**PETERSON BOULEVARD & SPACE VILLAGE AVENUE
COLORADO SPRINGS, CO**

TRAFFIC IMPACT STUDY

PROJECT NO. 017-1754

Add PCD File No. SP-17-009 & SF-18-016

FIGURE 2

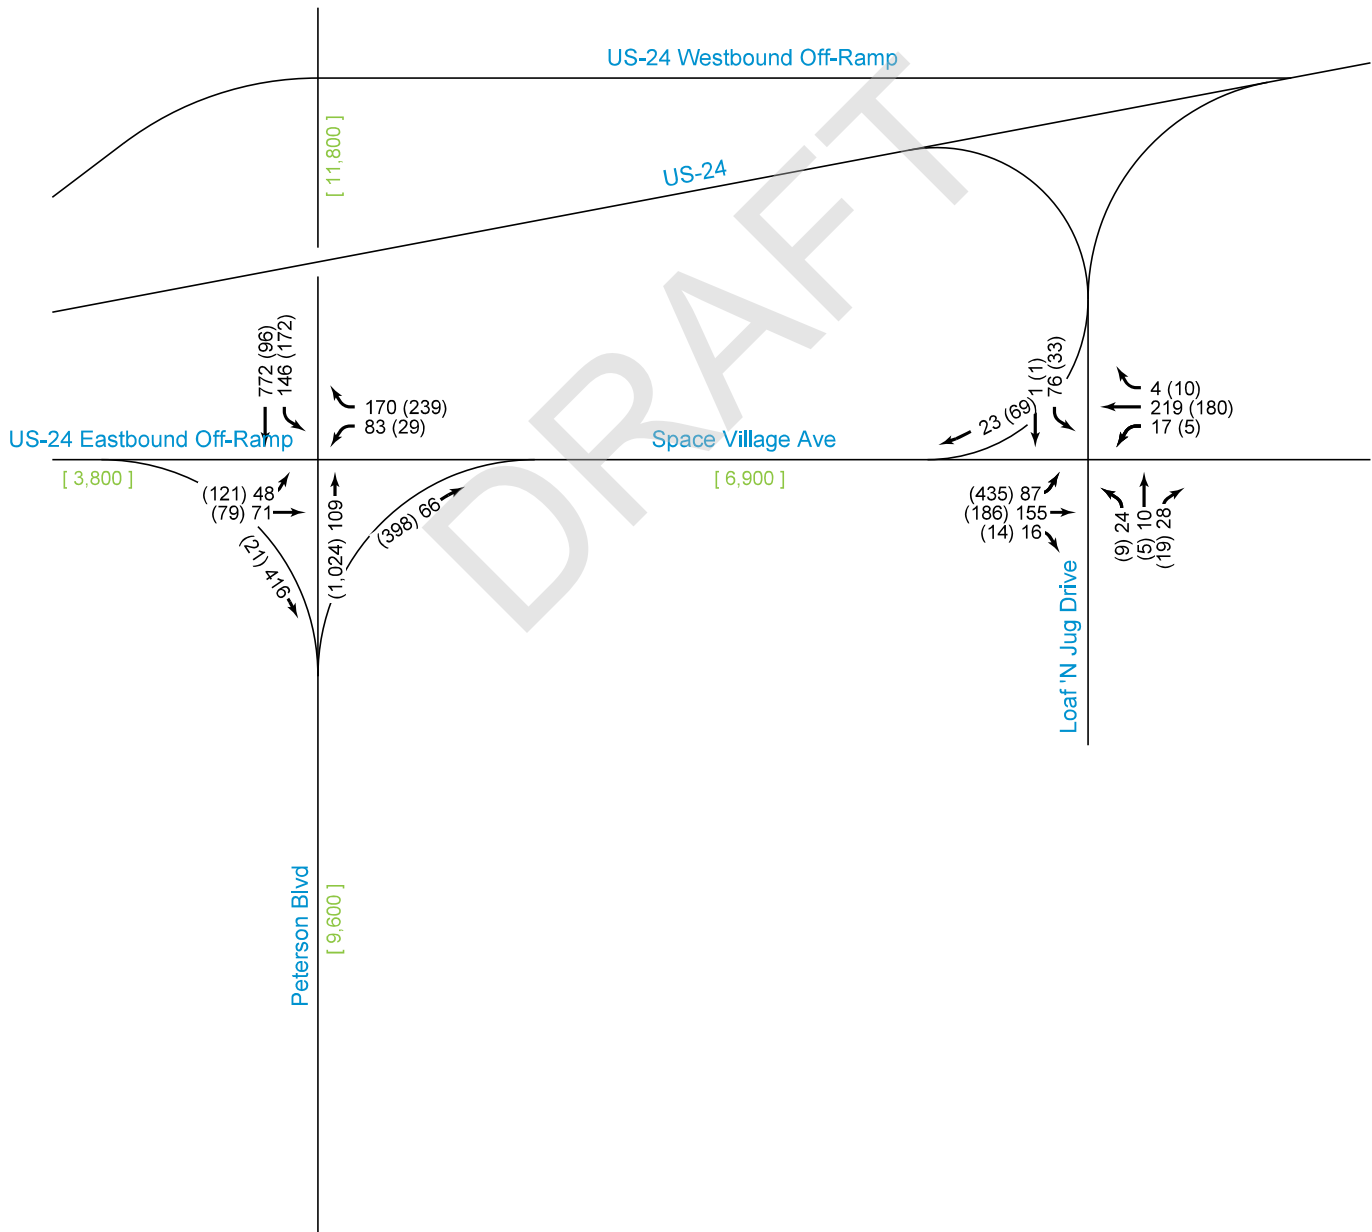
With this area involving multiple jurisdictions, for clarification identify (via narrative and/or exhibit) which jurisdiction owns/maintains which road.

FIGURE 4

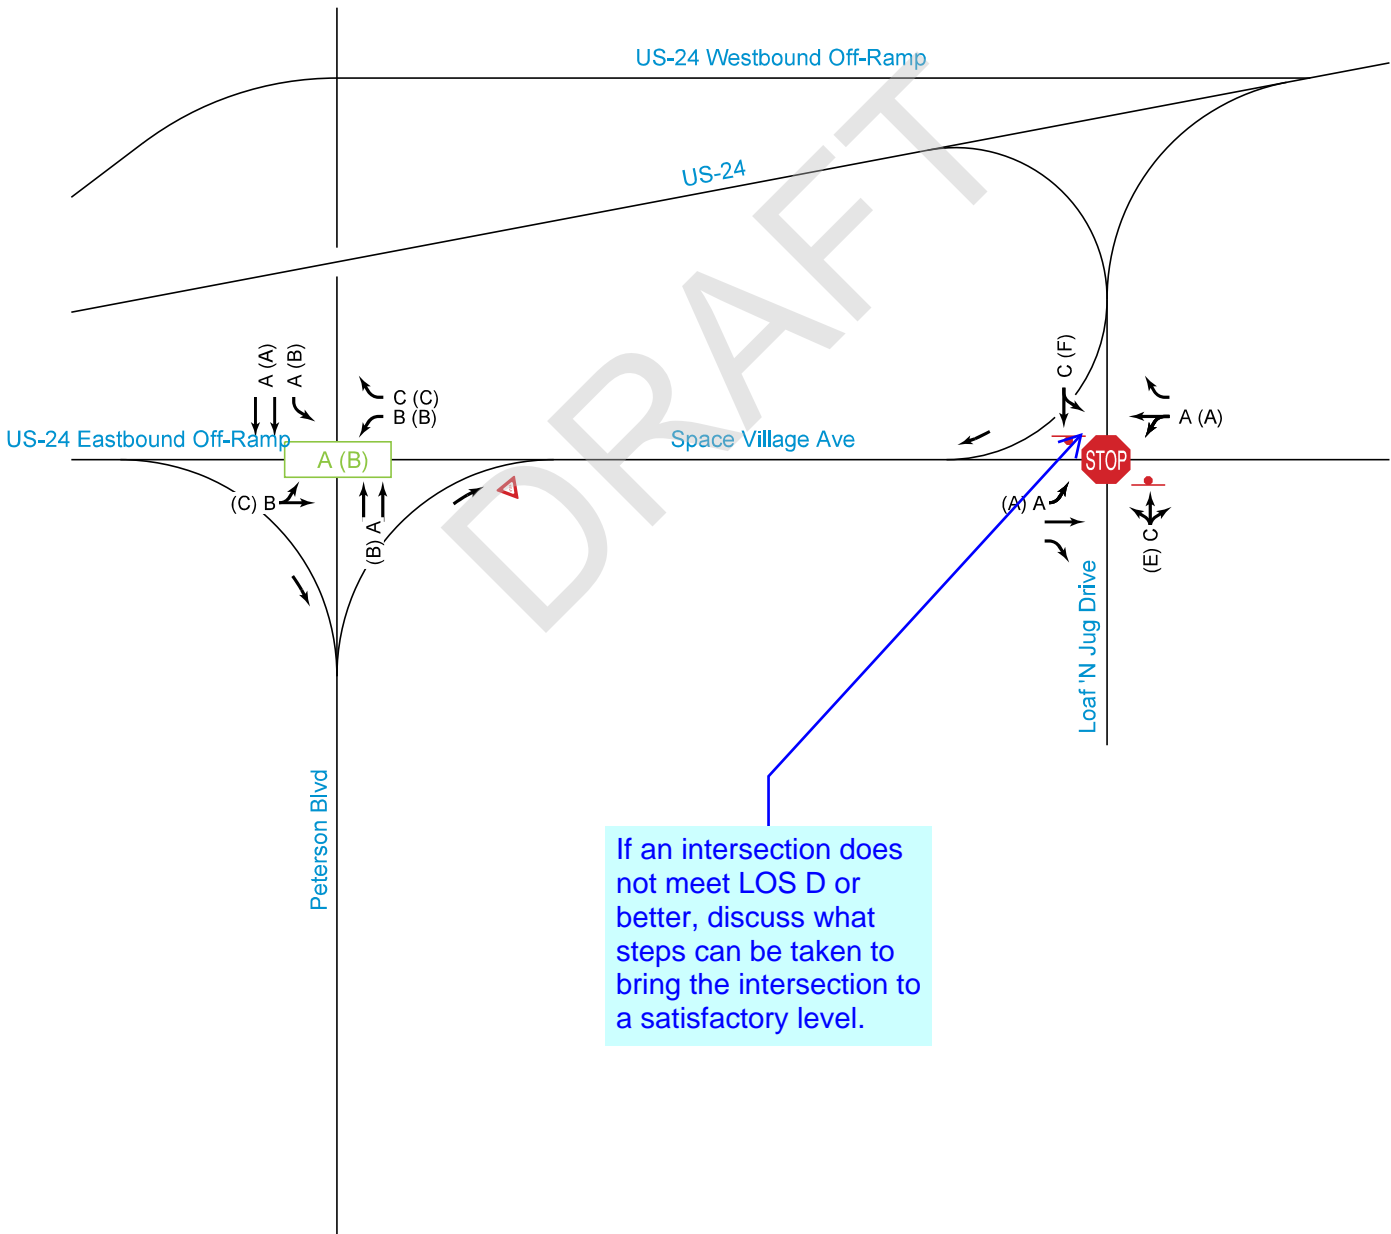
If an intersection does not meet LOS D or better, discuss what steps can be taken to bring the intersection to a satisfactory level.

With queueing backing onto US-24, why is the Synchro analysis at Space Village/Peterson be at LOS B or better?

Will add further discussion.

See #2 of new Section 5.0
